Your Ref  
 R/270/07  
 Our Ref  
 DSD/S/AR/R/2007/270  
 Date  
 30/11/2007  
 Contact  
 Tel 01634 824103  
 Fax 01634 824179

**Single storey Extension**

**The Old School House, Claigmar Road, Rustington.**

Block Plan - Scale 1:500

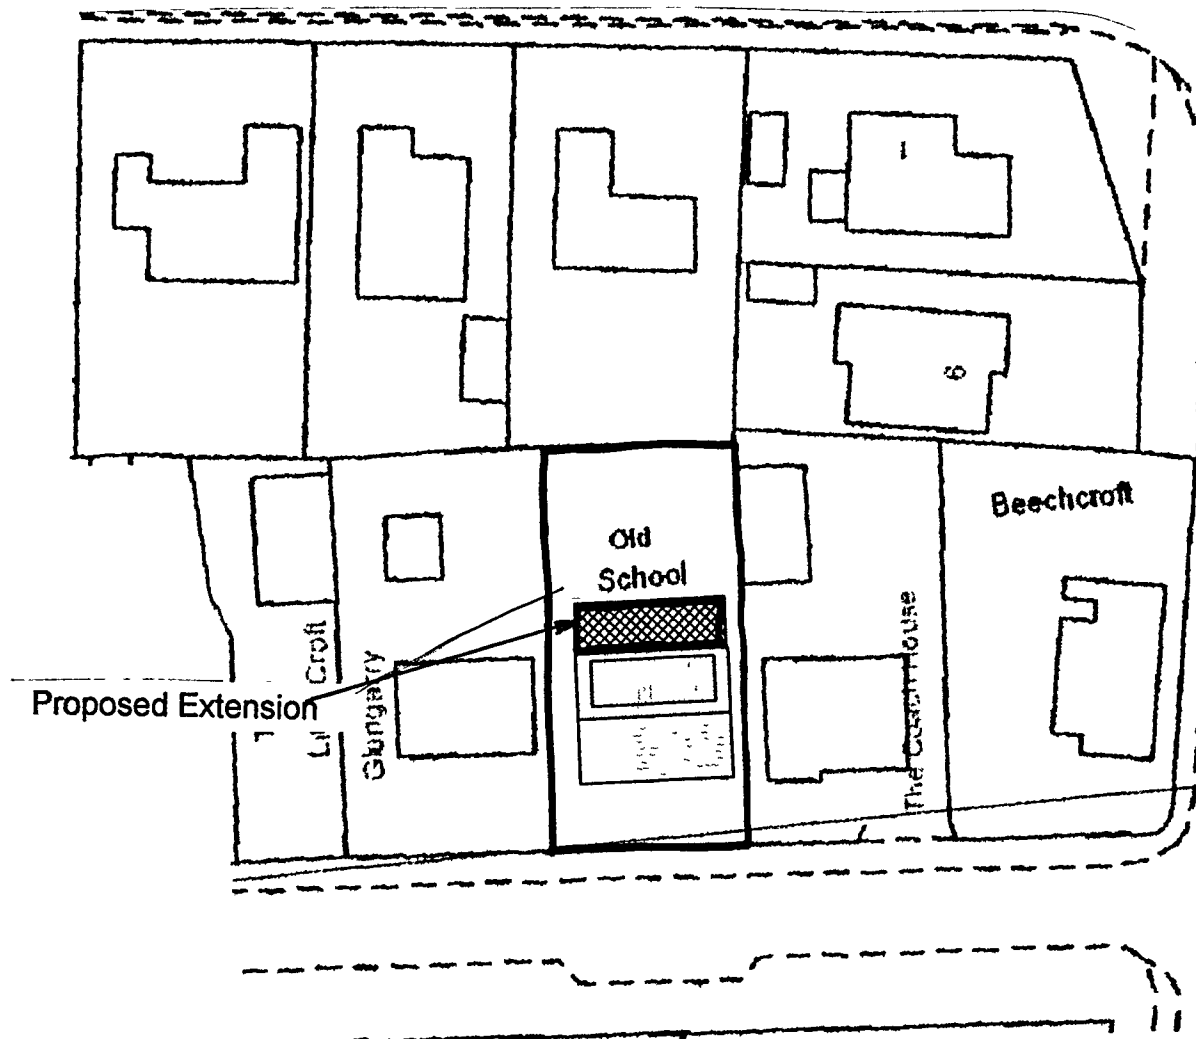
The applicant has not stated details of the proposed means of disposal of surface water from the site. This should not involve disposal to a public foul sewer.

We request that should this application receive planning approval, the following condition is attached to the consent: "Construction of the development shall not commence until details of the proposed means of surface water disposal have been submitted to, and approved by, the Local Planning Authority in consultation with Southern Water."

The Old School House

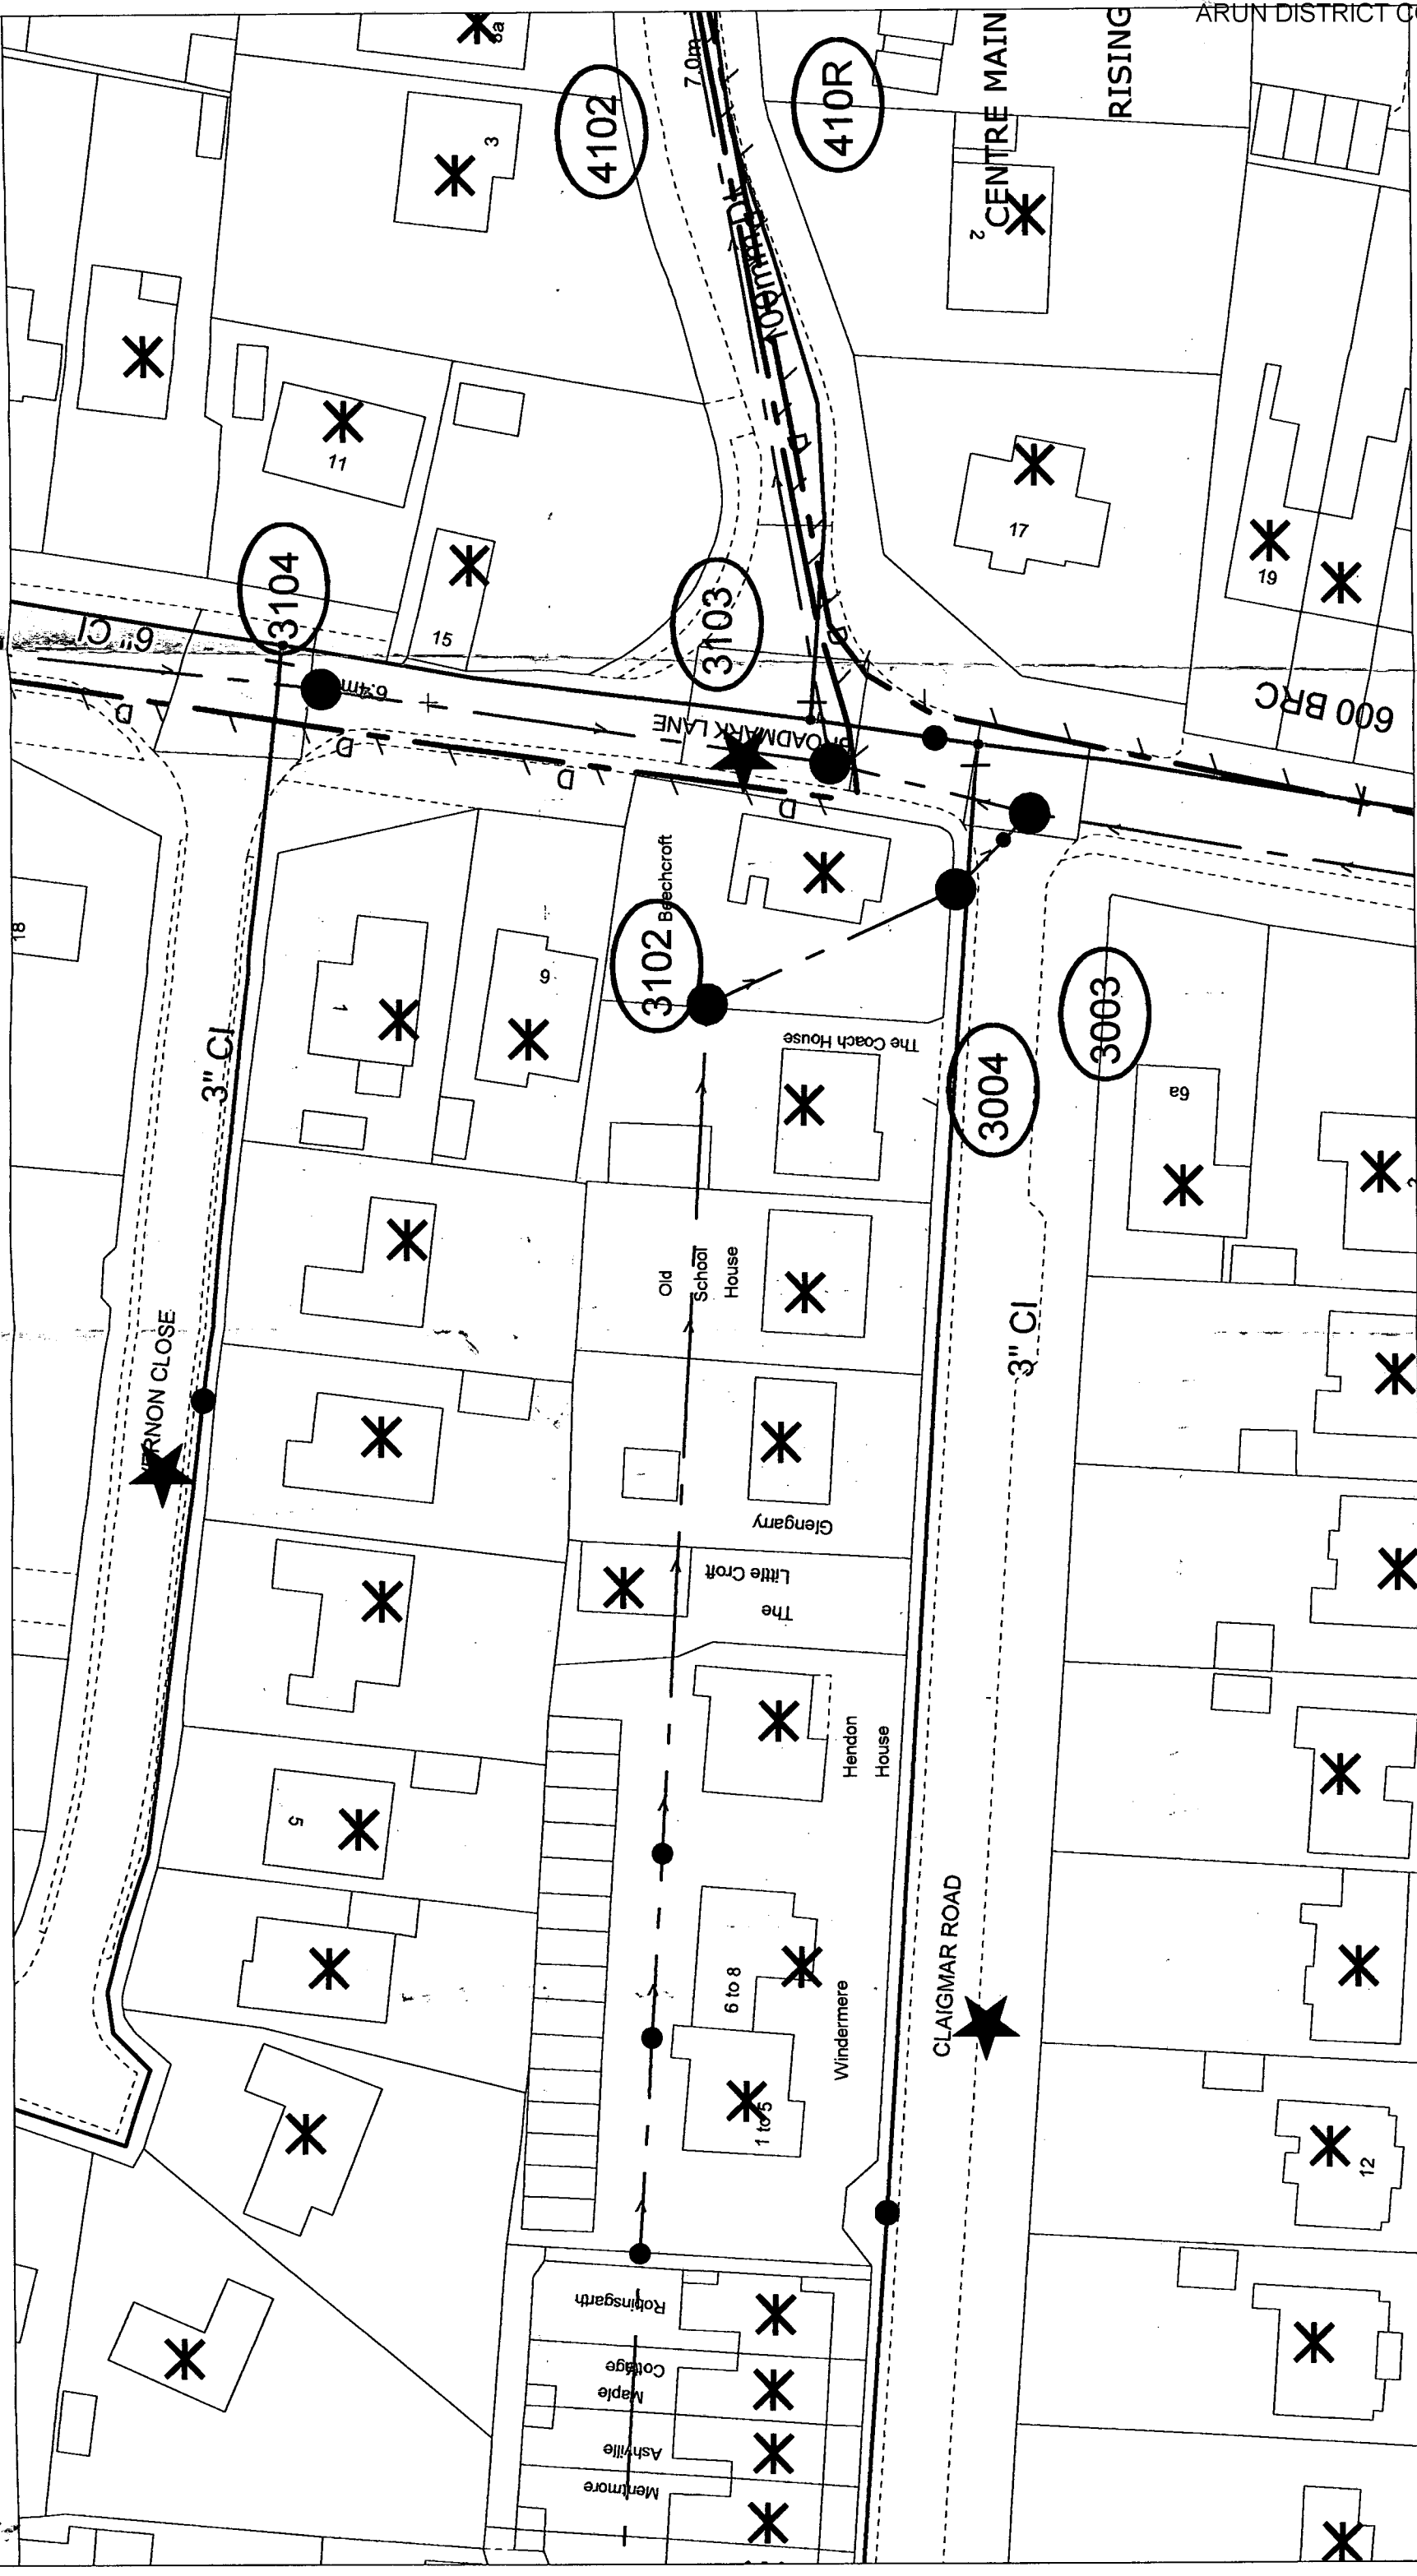
Please find attached a plan of the sewer records showing the approximate position of a public sewer in the vicinity of the site. The exact position of the public sewers must be determined on site by the applicant before the layout of the proposed development is finalised. Please note:

No development or new tree planting should be located within 3 metres either side of the centreline of the public sewer and all existing infrastructure should be protected during the course of construction works.

In order to protect drainage apparatus, Southern Water requests that if consent is granted, a condition is attached to the planning permission. For example "The developer must advise the local authority (in consultation with Southern Water) of the measures which will be undertaken to protect the public sewers, prior to the commencement of the development."
